Please ask for: Mrs D Johnson
Email: daun.johnson@arun.gov.uk
Telephone: 01903 737762
Our Ref: FG/57/22/PL
Your Ref:
Date: 31st March 2022

Application for Planning Permission

Development: Demolition and erection of 1 No new dwelling. This application is in CIL Zone 4 and is CIL Liable as new dwelling.
Location: 12 Little Paddocks Ferring BN12 5NJ

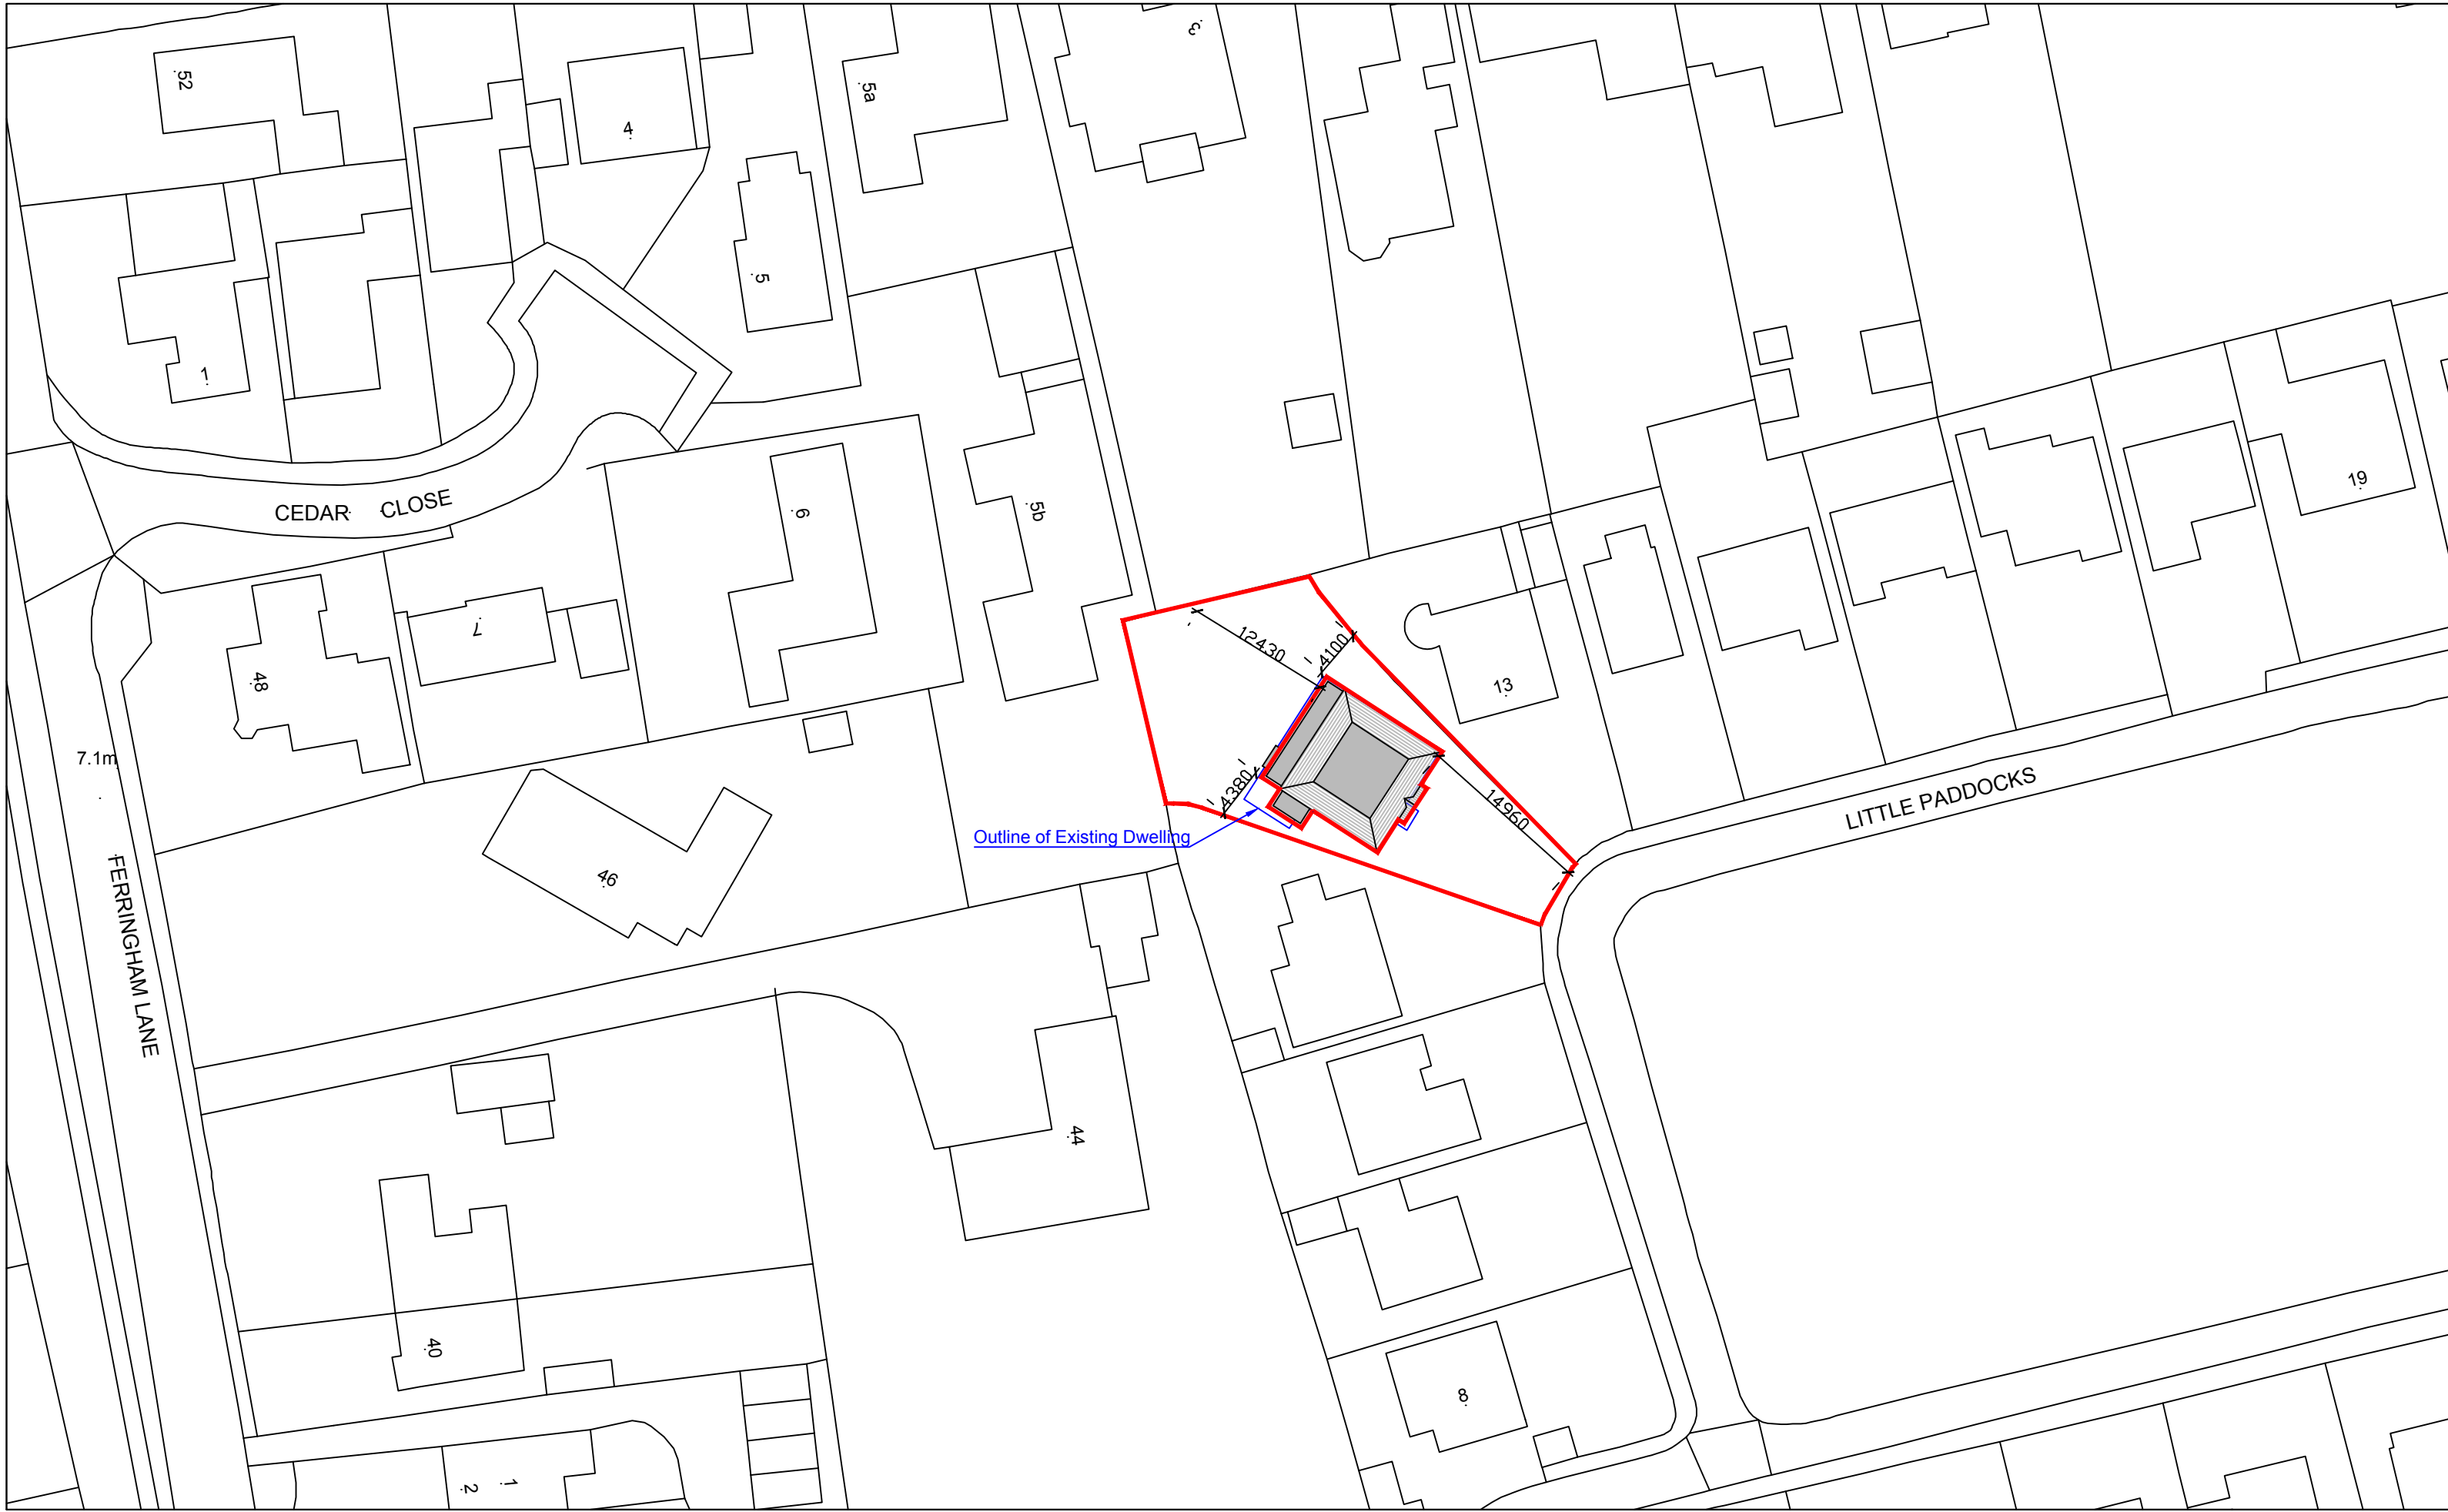
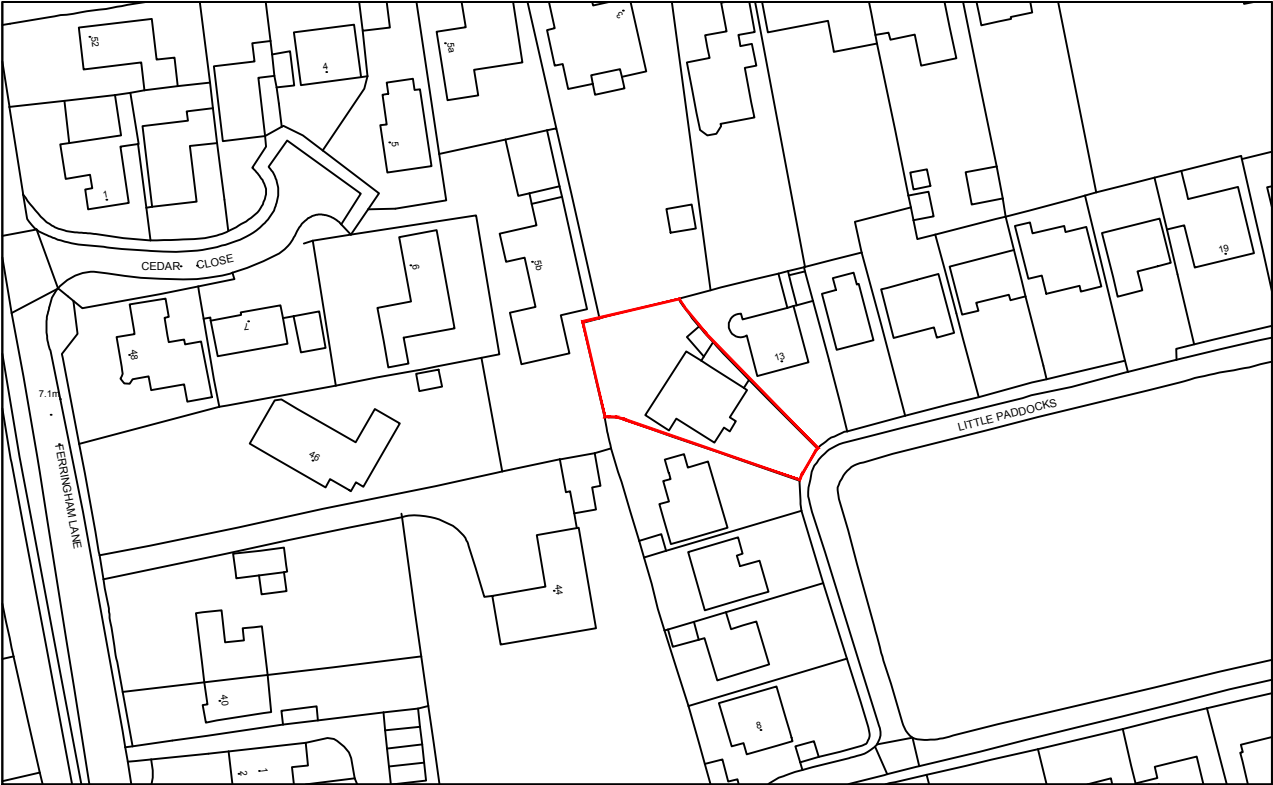
On either the block or site plan, please show the outline of the existing dwelling.
